**EL PASO COUNTY PLANNING AND  
 COMMUNITY DEVELOPMENT  
 DEPARTMENT**

Phase I  
 01/17/20

**GRADING AND EROSION CONTROL PLAN CHECKLIST**

MOUNTAIN VIEW ACADEMY
SITE DEVELOPMENT PLAN
SITE PLAN

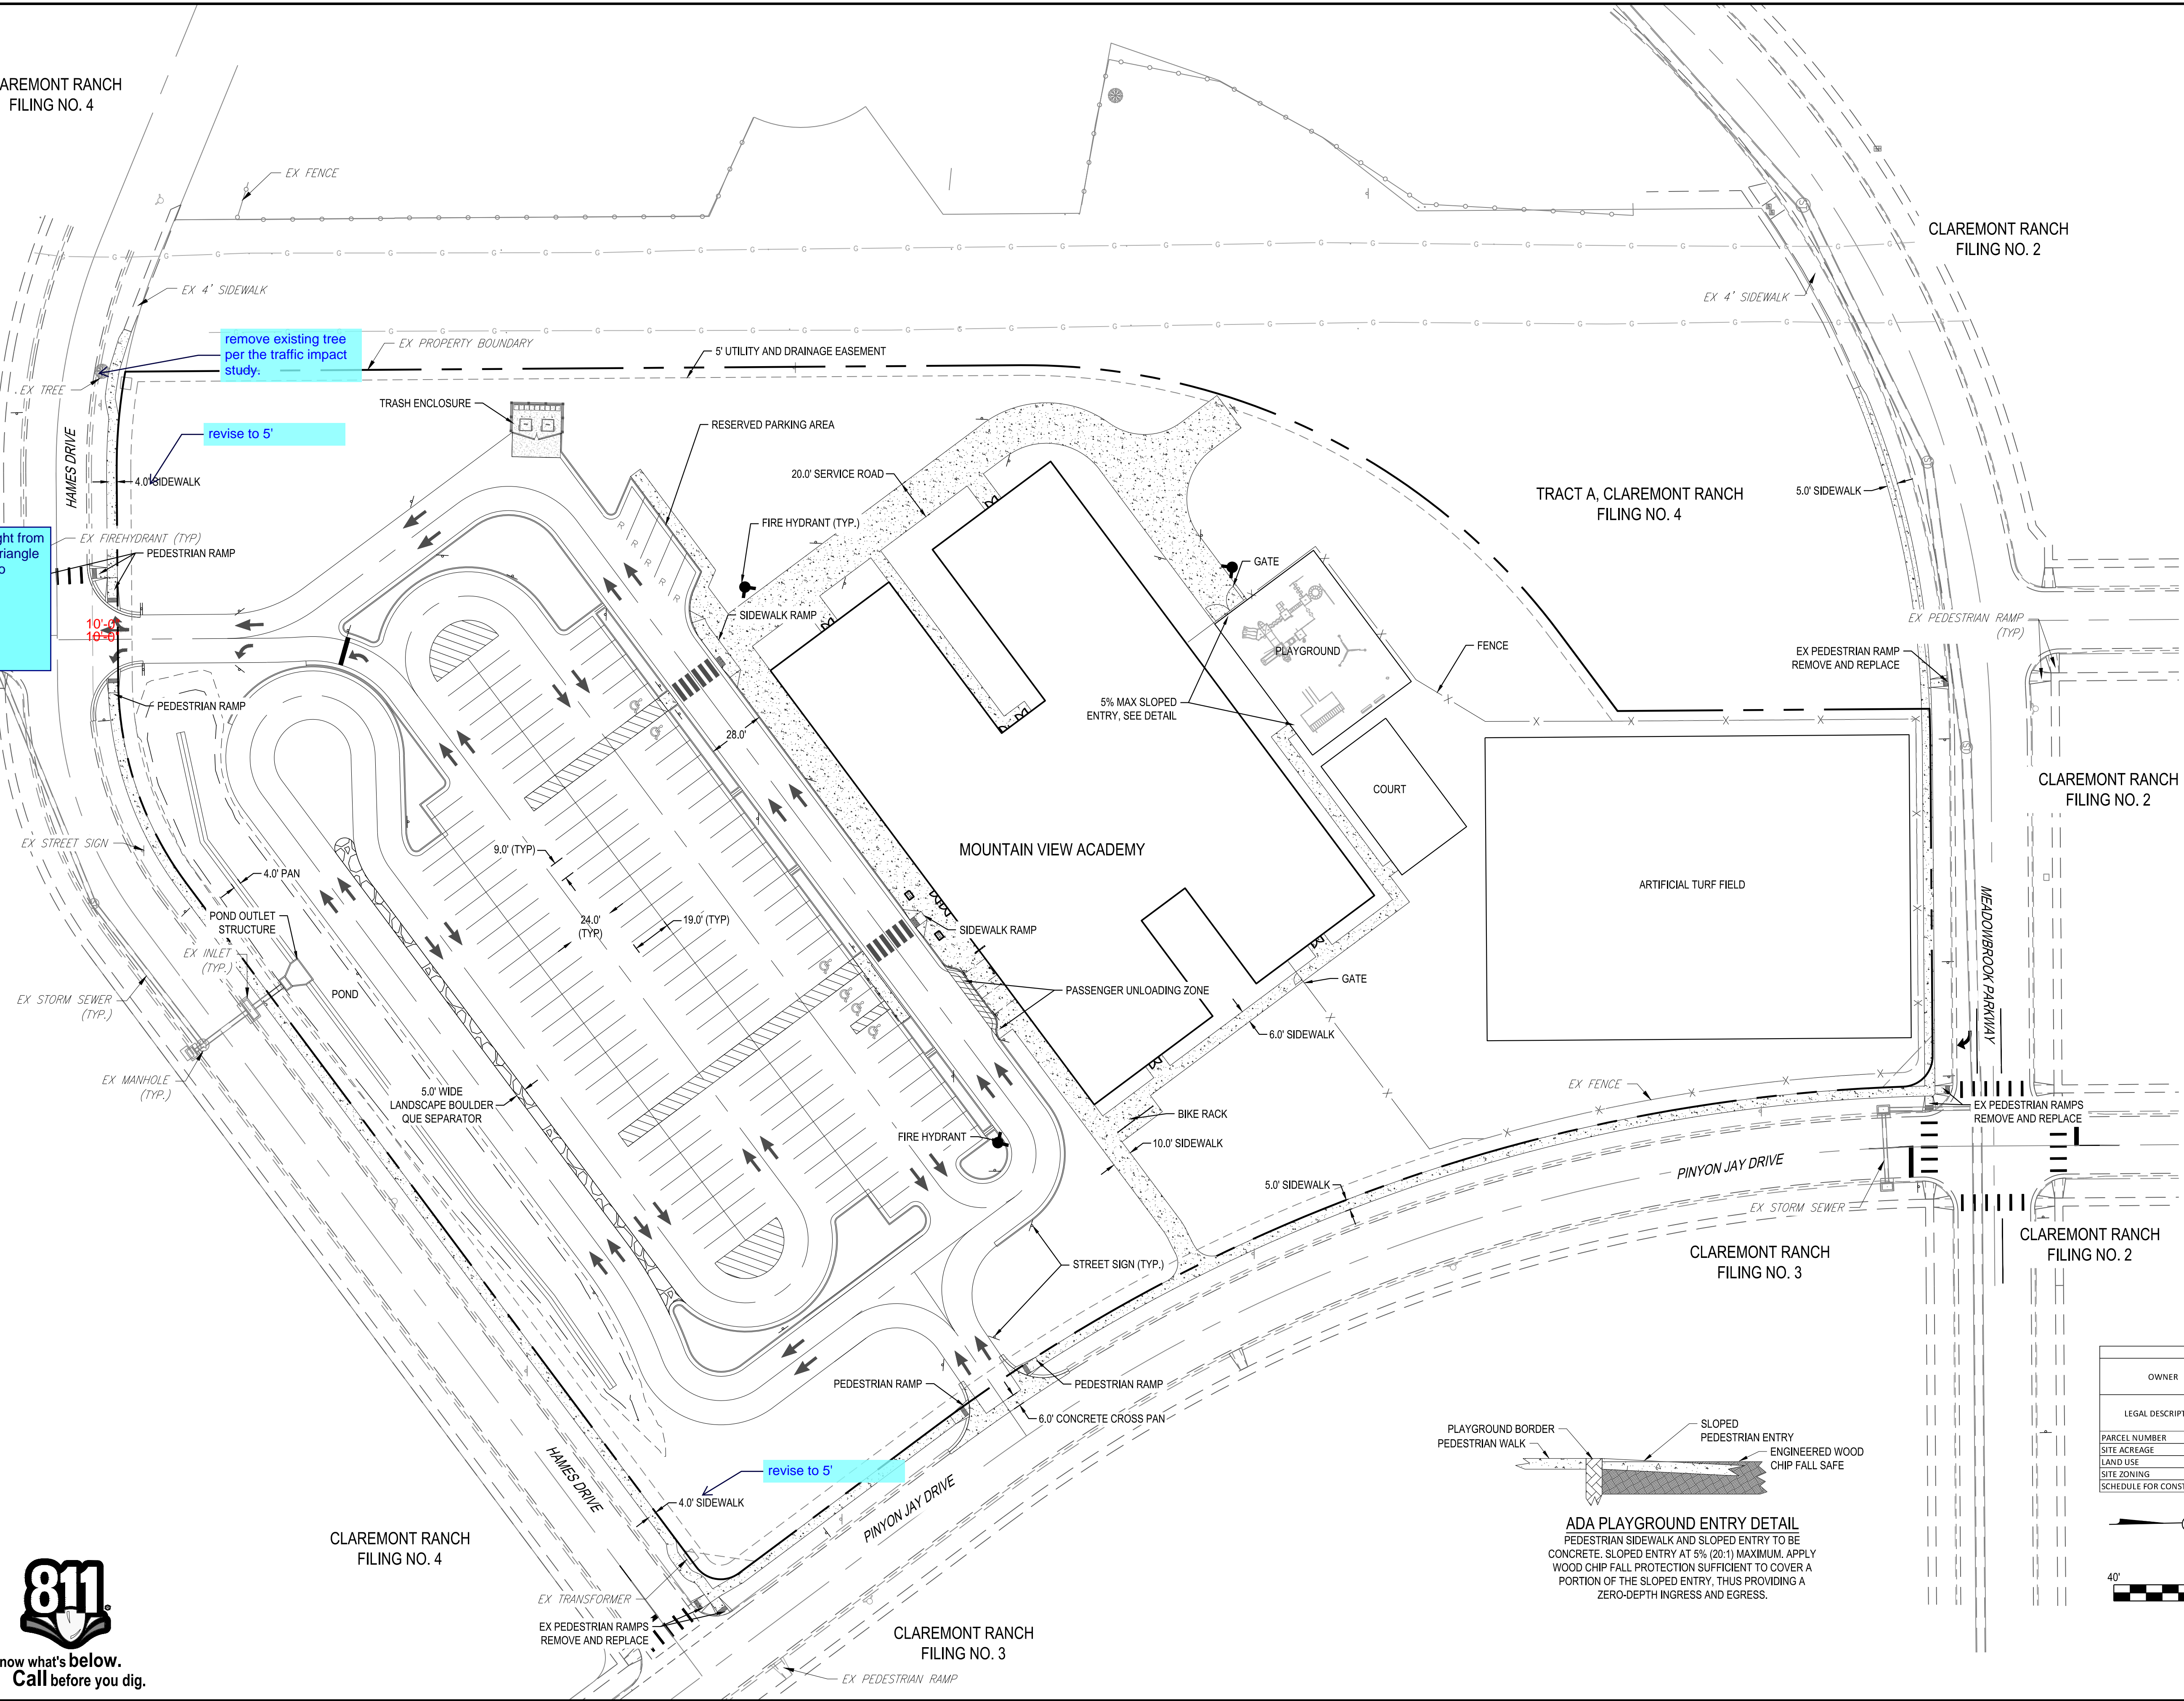
l	Existing and proposed contours 2 feet or less (except for hillside).	✓	✓
m	Limits of disturbance delineating all anticipated areas of soil disturbance.	✓	X
n	Identify and protect areas outside of the construction site boundary with existing fencing, construction fencing or other methods as appropriate.	✓	✓
o	Offsite grading clearly shown and called out. - None	N/A	N/A
p	Areas of cut and fill identified. - Final grade to be determined by contractor based on site conditions	N/A	X
q	Conclusions from soils/geotechnical report and geologic hazards report incorporated in grading design (slopes, embankments, materials, mitigation, etc.)	✓	✓
r	Proposed slopes steeper than 3:1 with top and toe of slope delineated. Erosion control blanketing or other protective covering required. - No slopes steeper than 3:1	N/A	N/A
s	Stormwater flow direction arrows.	✓	X
t	Location of any dedicated asphalt / concrete batch plants. - None	N/A	N/A

Reviewed text on CDs. Add GEC Sheets to CDs
